Appendix 8 Response From The Highway Authority

Land at 40 Victoria Road, Fleur-De Lis

Having reviewed all documents submitted on-line for the above PAC consultation, the Highway Authority would comment as follows:

Figure 4: Proposed access arrangements

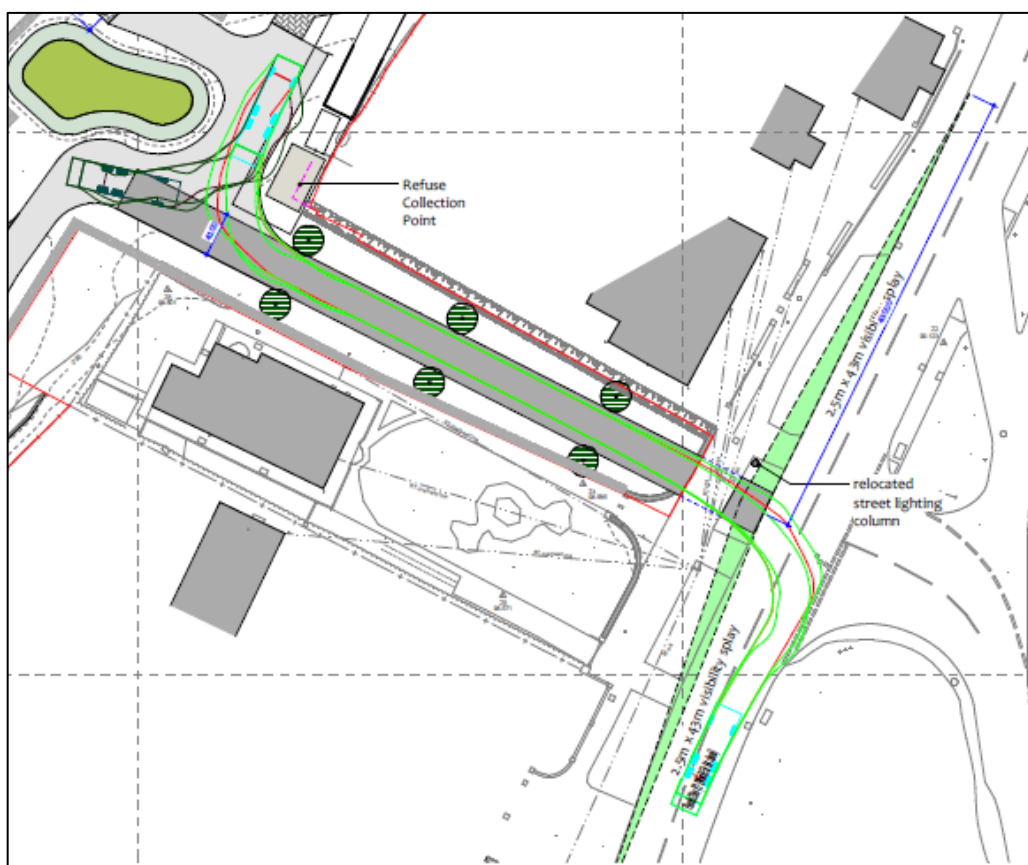
- The principle of developing 5 plots at this location is **acceptable** in highway safety terms, give that a shared private driveway with a minimum width of 4.1m is proposed, which incorporates a turning facility to cater for calling service and delivery vehicles. Whilst the section of driveway fronting Plots 3-5 narrows, there is a passing bay proposed which would enable 2 vehicles to pass each other unhindered, with adequate forward visibility;

- A vision splay of 2.5m x 43m is shown on the submitted plan, which is adequate to cater for the speed of traffic on Victoria Road and thus would amply meet the criteria of Manual for Streets;

The existing access which serves no.40 Victoria Road would need to be stopped-up in a manner to be agreed in writing with the LPA prior to the proposed new shared private driveway coming into beneficial use, with the brand new access requiring a properly-formed vehicular crossing, constructed under licence/agreement with the Highway Authority. It is acknowledged that the existing street-lighting column adjacent to the proposed new site access has been catered for on the submitted layout plan in terms of its relocation, which again would require the consent of the Highway Authority to relocate, at the applicant's cost.

there is clearly an existing dropped crossing within the highway (crossing a grassed verge). This is the area which we would want to be closed off/stopped up, to prevent a multiplicity of accesses in close proximity along a distributor road. Whilst this is outside of your client's ownership, this is considered irrelevant as it's within the adopted highway. Leaving this access in situ whilst adding an access to serve the proposed new shared private drive would result in a total of 4 accesses between no.41 and 35 Victoria Road, which would be excessive on a distributor road. The existing access serving no.40 would be superfluous with the creation of the new access. In addition, the existing and proposed accesses would only just over 1m apart.

Figure 5: Proposed plot layout and driveways

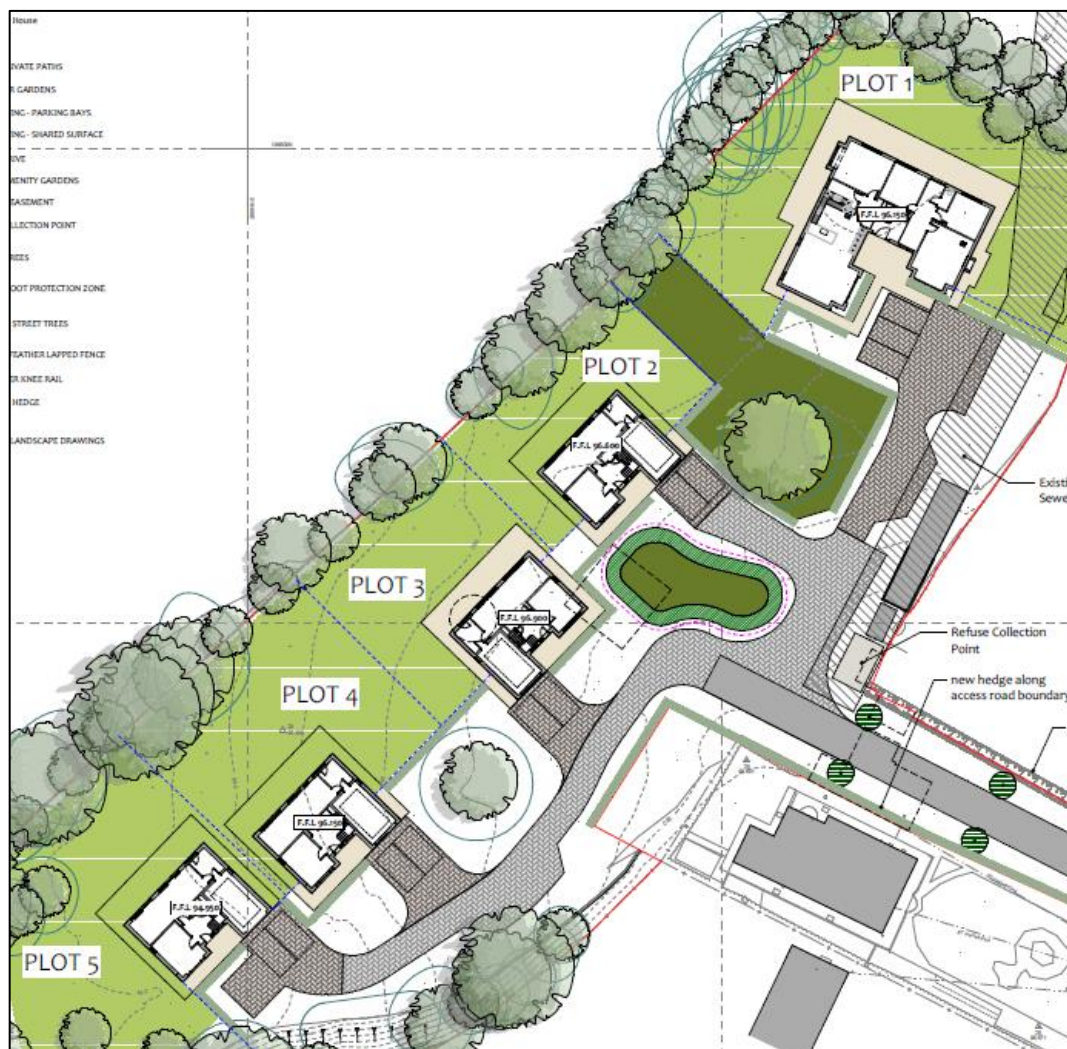
- The proposed private driveway arrangement incorporates a turning facility to cater for calling service and delivery vehicles. This would prevent vehicles from reversing onto The B4252/ Victoria Road, which is classed as a distributor road in the LDP. Therefore it is essential that any future formal planning application submission incorporates a turning facility of similar proportions, to prevent reversing manoeuvres to and from the highway. Ideally, a vehicle swept path drawing should be submitted as part of any future application which demonstrates the largest vehicle which could safely enter and leave the site in a forward gear;

- Parking throughout the development will need to be provided in accordance with LPD5 Car Parking Standards. Assuming that each dwelling would have at least 3 bedrooms, this would lead to a requirement of 3 off-street parking spaces per dwelling. Standard external spaces need to measure 2.6m x 4.8m each, with garage spaces requiring clear internal dimensions of 3m x 6m for a single garage space, or 6m x 6m for a double garage. There appears to be ample scope to achieve this.
